Our Ref: AW/24/19/L

Application for Listed Building Consent for Alterations, Extension or Demolition of a Listed Building

Development Proposed two storey side extension to Grade II listed dwelling.

Location Culver Cottage 37 Aldwick Road Bognor Regis

LOCATION & BLOCK PLAN
Dwg. No. 599-100

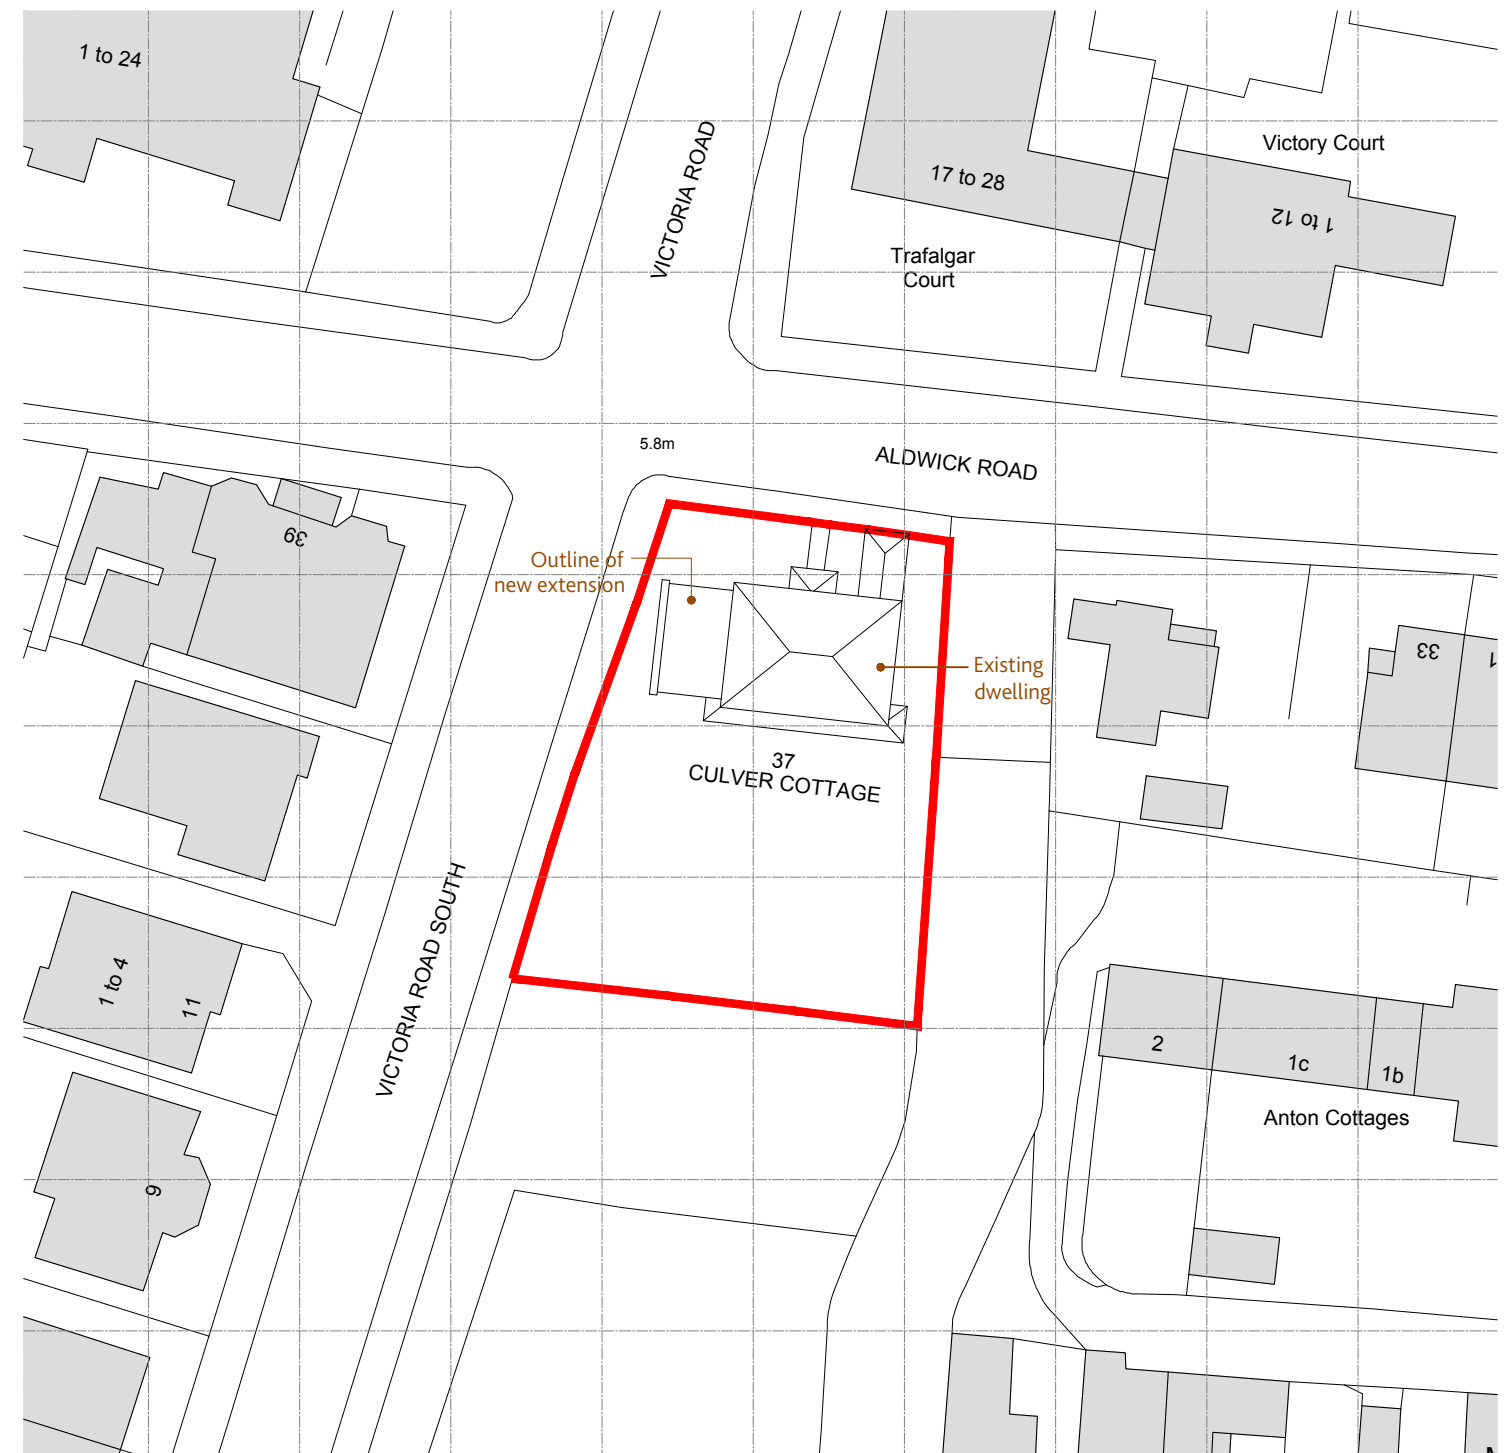
Block Plan

Please submit 1 electronic or 3 paper copies of a block/site plan which includes all dimensions from the proposed extension to all site boundaries. Further details of what must be included on the plan can be found in the National Validation Requirements.
